WEST SUSSEX COUNTY COUNCIL CONSULTATION

TO:	Arun District Council - FAO: A Gardner
FROM:	WSCC - Highways Authority
DATE:	24 September 2021
LOCATION:	Land East of Yapton Lane, Walberton, BN18 0LJ
SUBJECT:	WA/80/21/OUT Outline application with all matters reserved (except access) for up to 75 No. dwellings. This application affects the setting of a listed building, affects the character & appearance of the Walberton Village Conservation Area & is a Departure from the Development Plan.
RECOMMENDATION:	More Information

Document/Revision Number

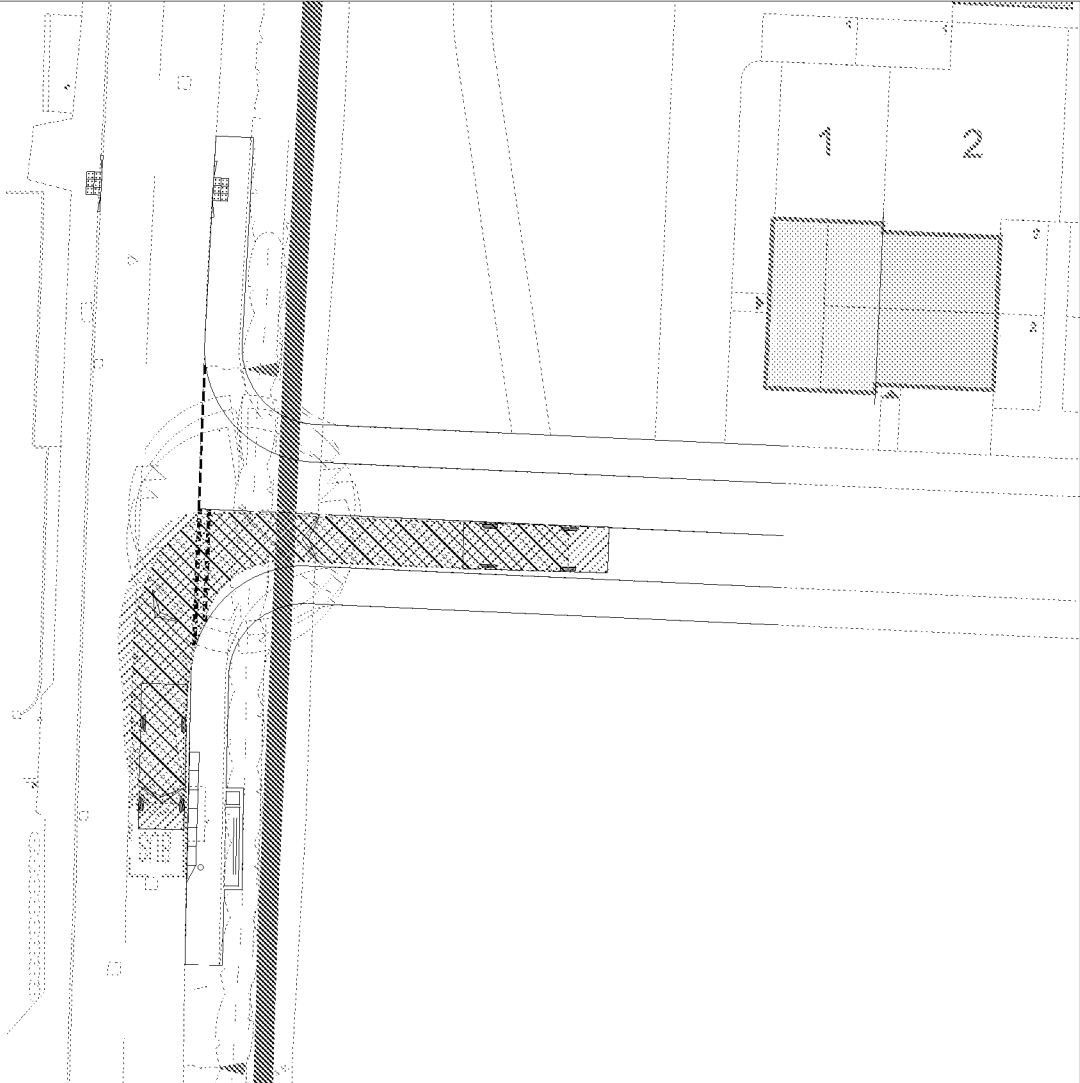
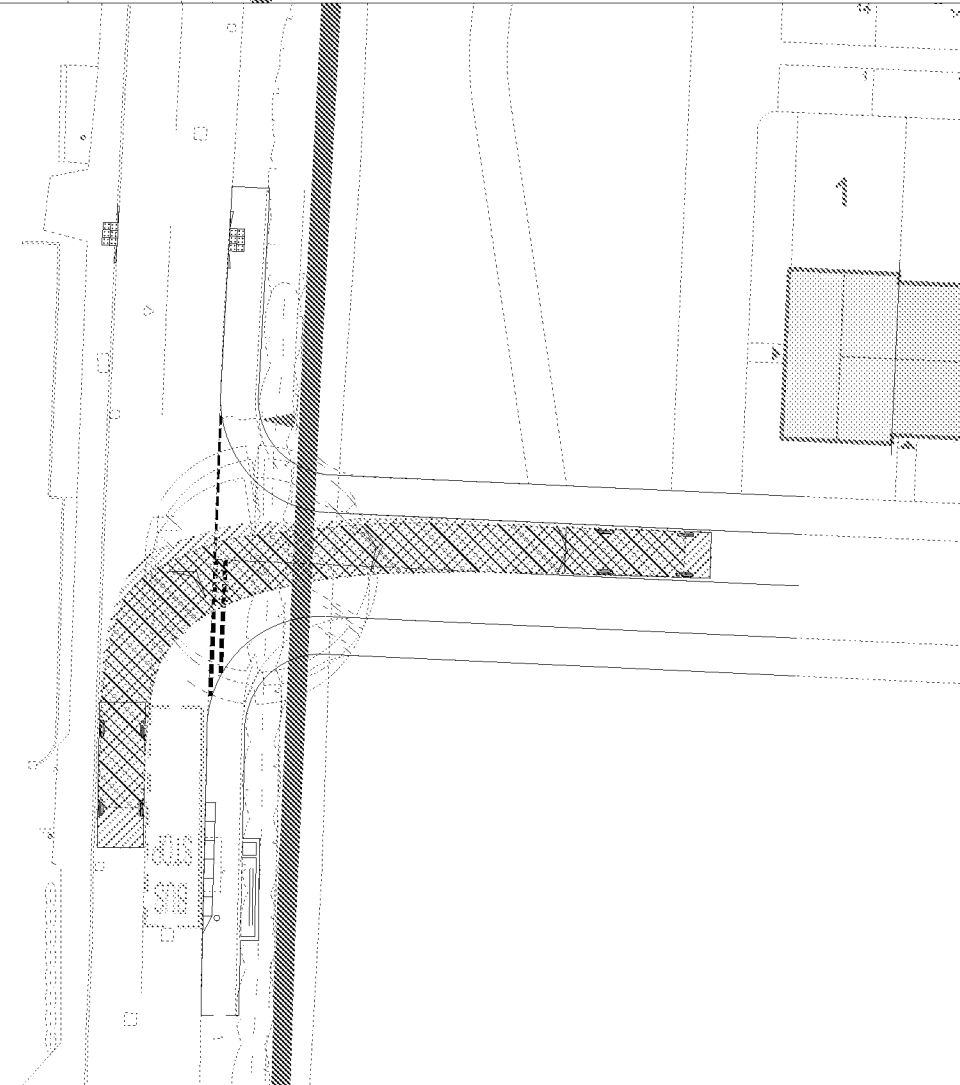
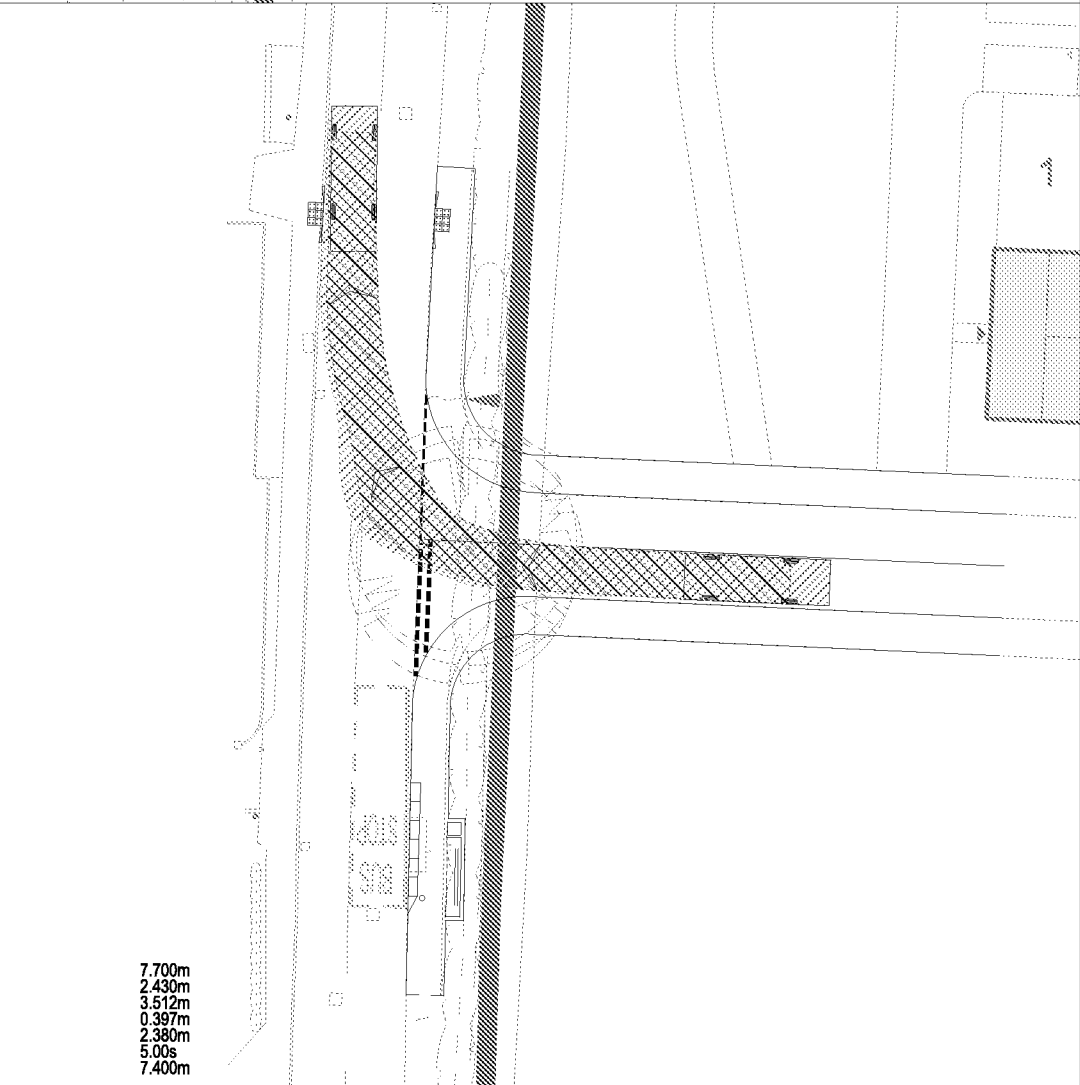
The bellmouth will be 5.5m wide with 6m kerb radii. Swept path tracking plans show that a refuse vehicle and fire tender can manoeuvre the site access. Footway either side of the access point will link to a new dropped kerb tactile paved crossing of Yapton Road to the north and upgraded bus stop to the south (new flag, post, shelter, raised kerb and road markings). The bus stop further south on the west side of Yapton Road will also be upgraded with raised kerb and road markings. There will also be a dropped kerb tactile paving crossing point to the north (near Avisford Park Road). Plans show an internal footway joining in vicinity to the Manser Road bus stop also which already features a dropped kerb tactile paving crossing of Yapton Road.

The Stage 1 Road Safety Audit (RSA) to cover access and pedestrian crossing points and accompanying Designers Response should be provided.

- Stage 1 RSA and Designers Response
- Demonstrate that baseline figures (June 2021 traffic counts) are similar to pre-Covid levels through comparison with historical traffic counts (modelling may require updating).
- Consult with Parish Council on their willingness to maintain/ views of bus shelter.
- Consideration to appropriateness of PROW 333 route and possible upgrades.
- Minor updates to TPS (or this can be provided through the legal agreement).
